From: Anita Gardner
Sent: 21 December 2017 10:58
To: Planning.Responses
Subject: FW: Planning Consultation on: EP/138/17/PL

APPLICATION EP/138/17/PL

Site Address: Land Rear of Beechlands Cottages Beechlands Close East
Preston BN16 1JT

Description of Works: Demolition of existing buildings & erection of 3 no. dwellings with associated parking, alterations to existing access & relocation of staircase to flats

Proposed Site Plan, Block Plan
and Location Plan

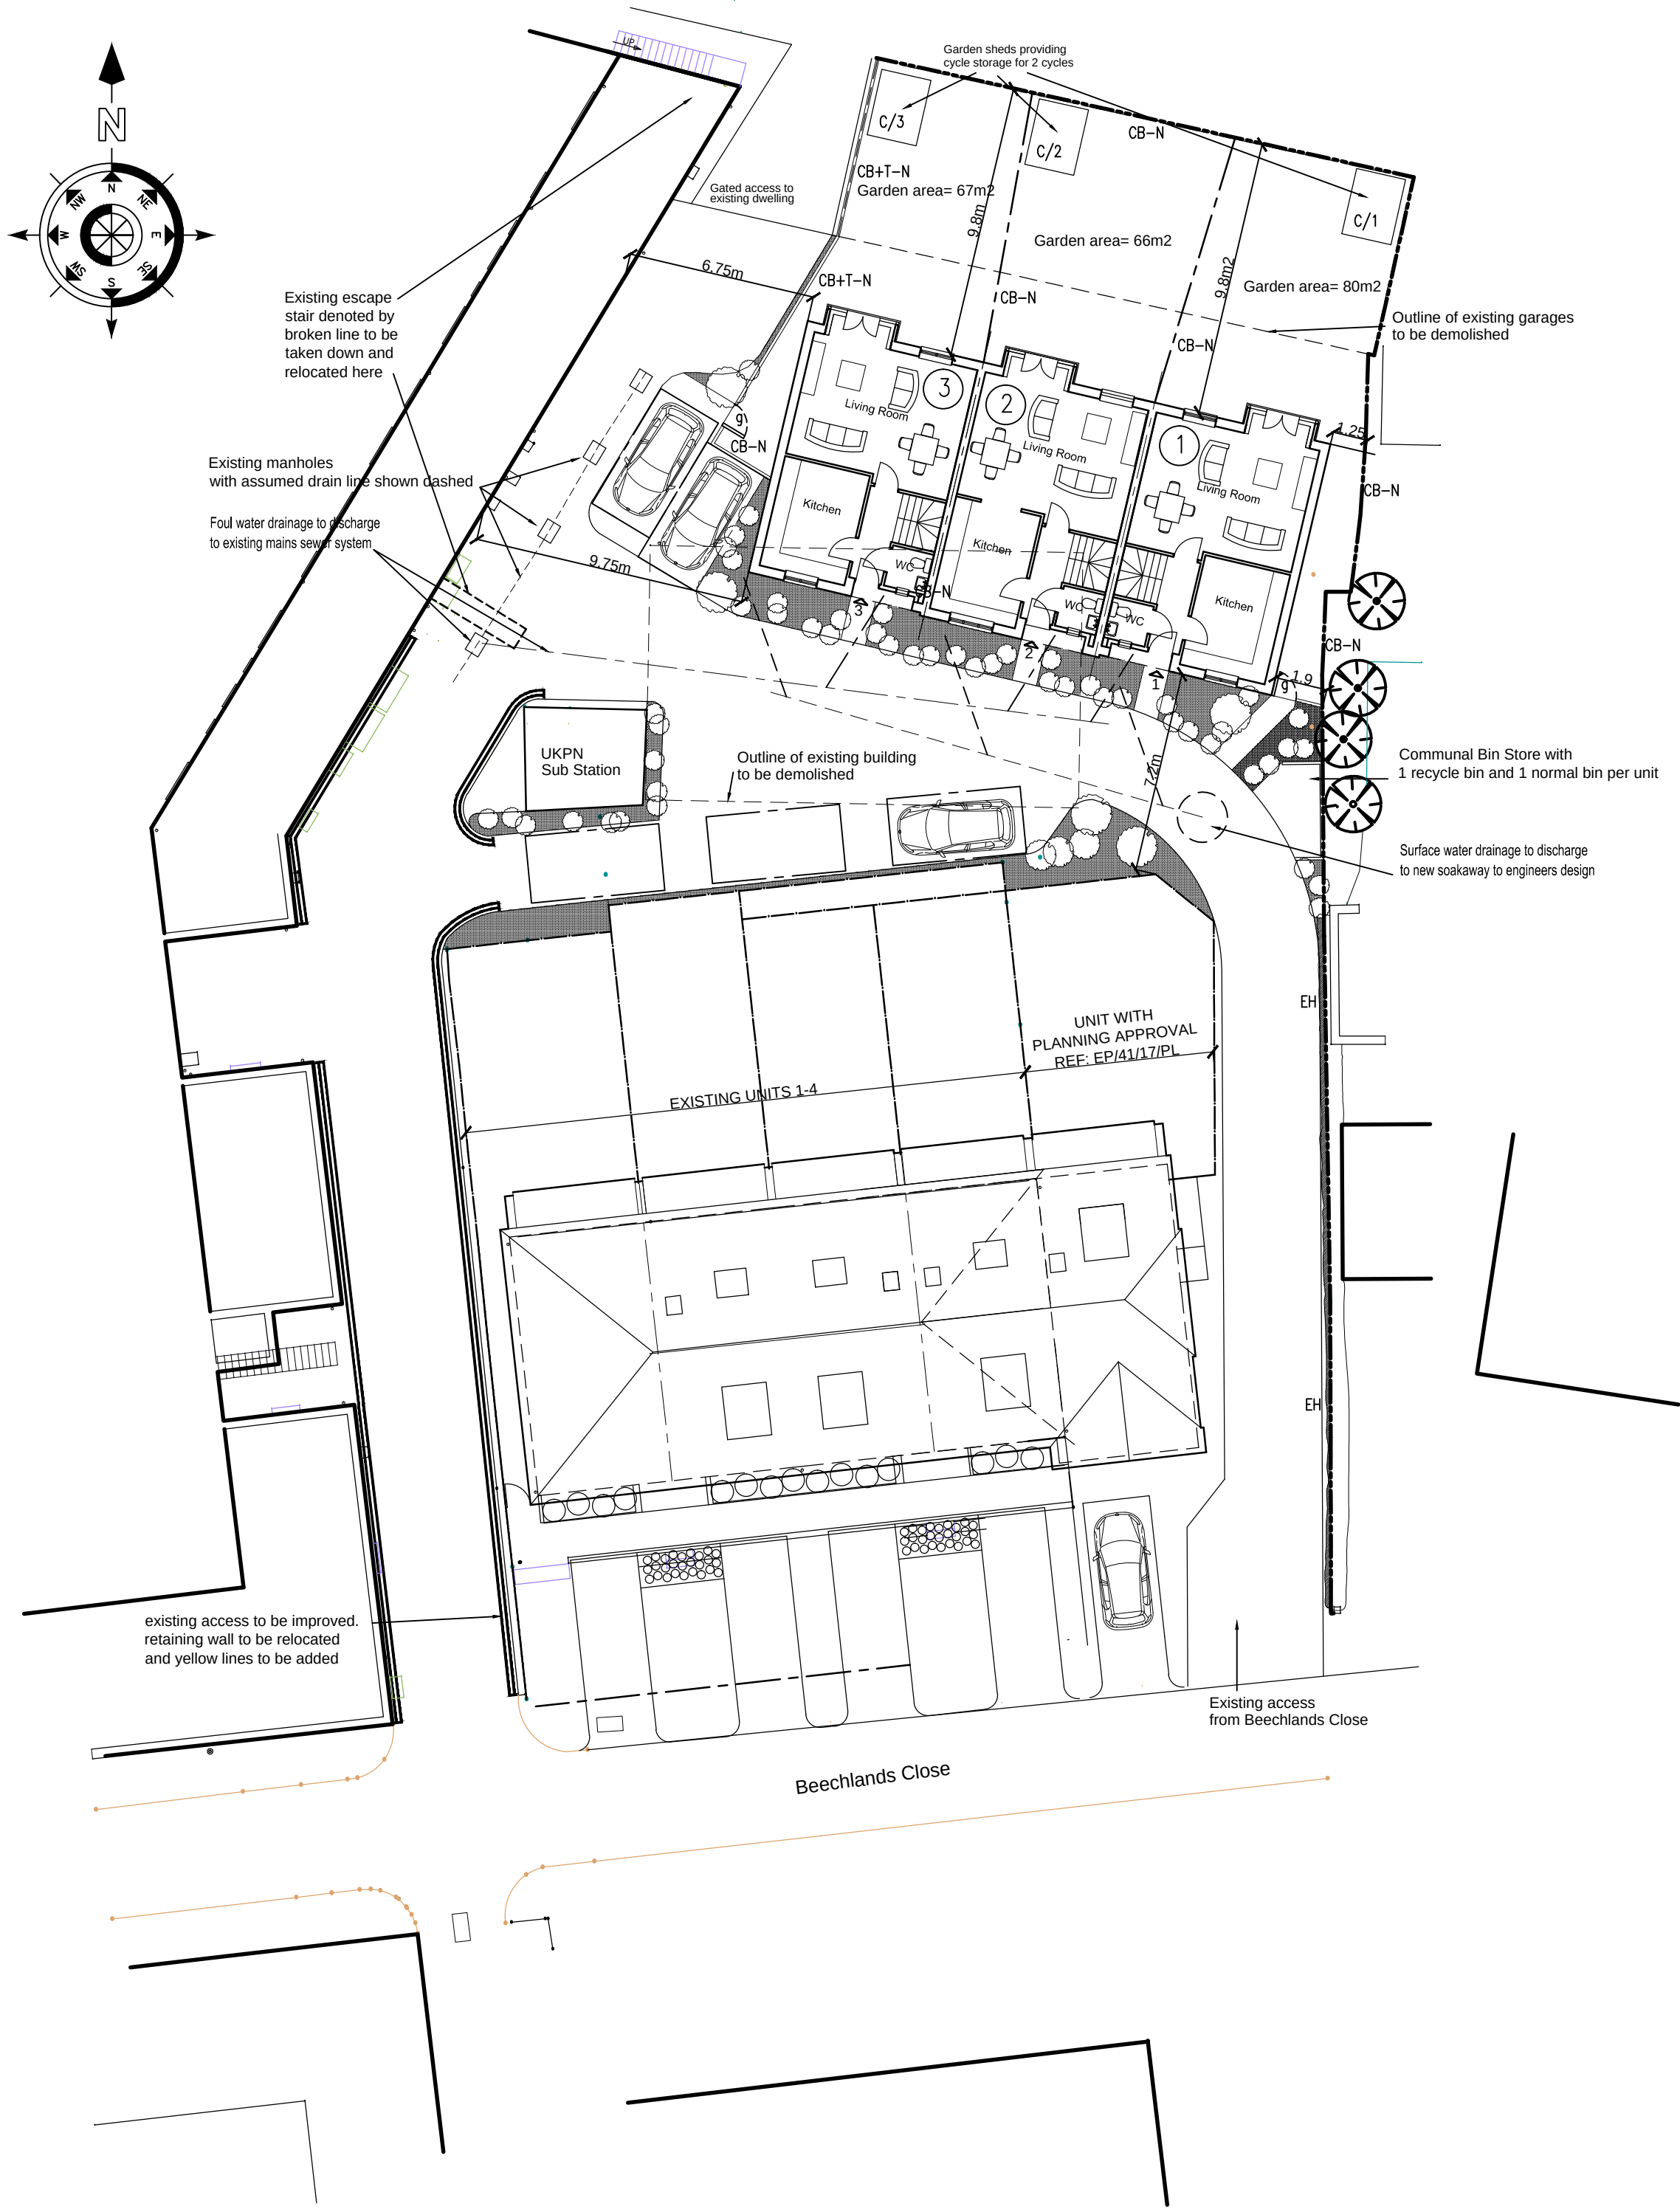
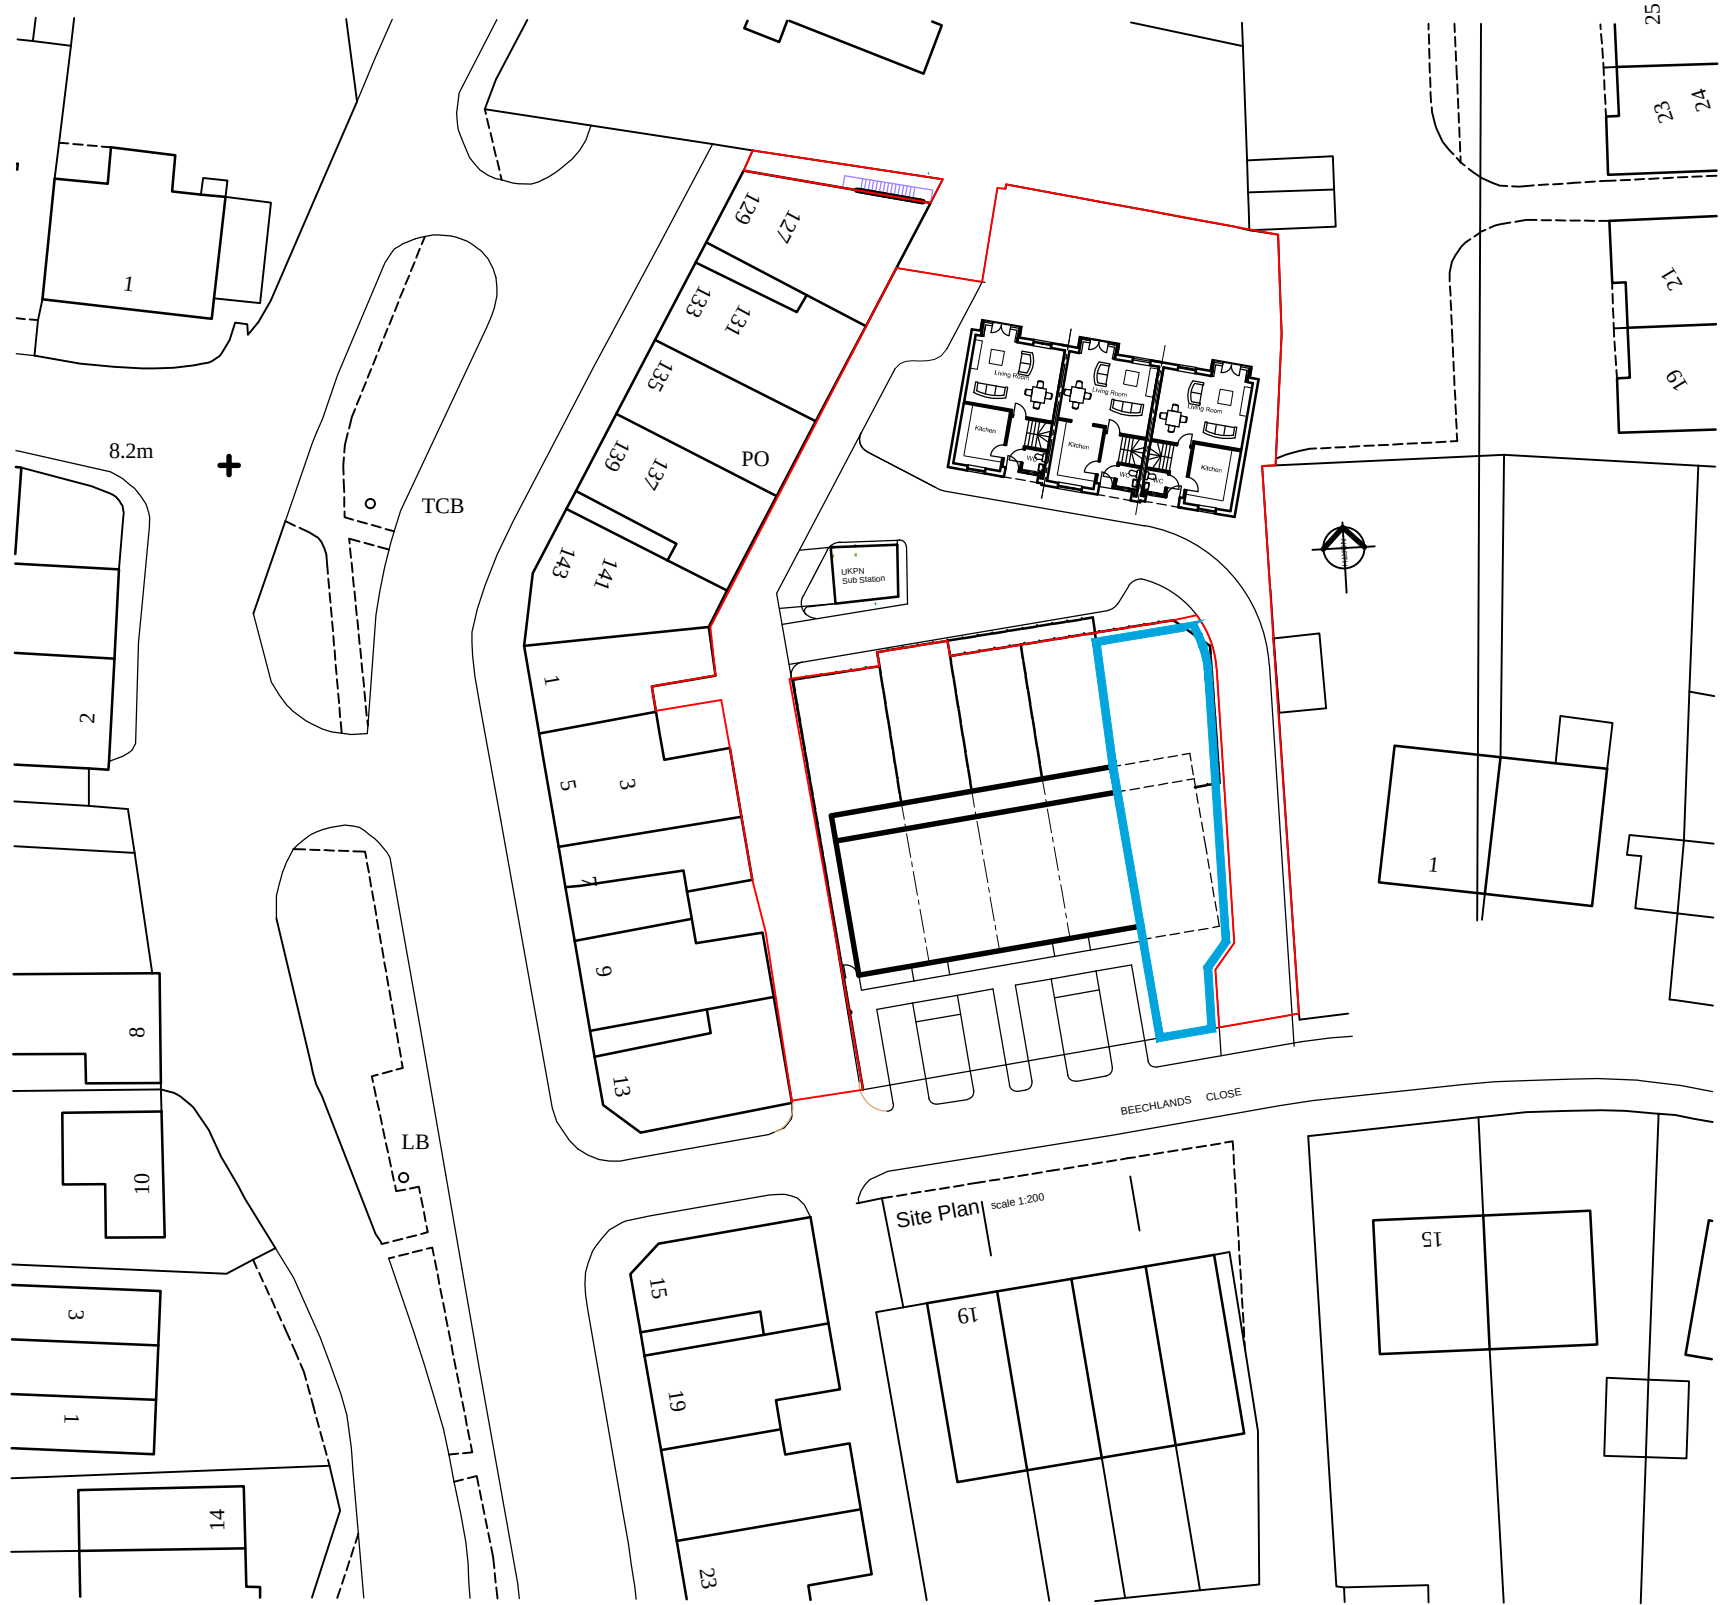
The provision of suitable and sufficient means of waste storage is a necessity for food premises in order to comply with Food Law. It would appear that the application does not sufficiently address the matter of where food premises such as 'One Stop' will find adequate waste storage facilities should the development proceed in its current form.
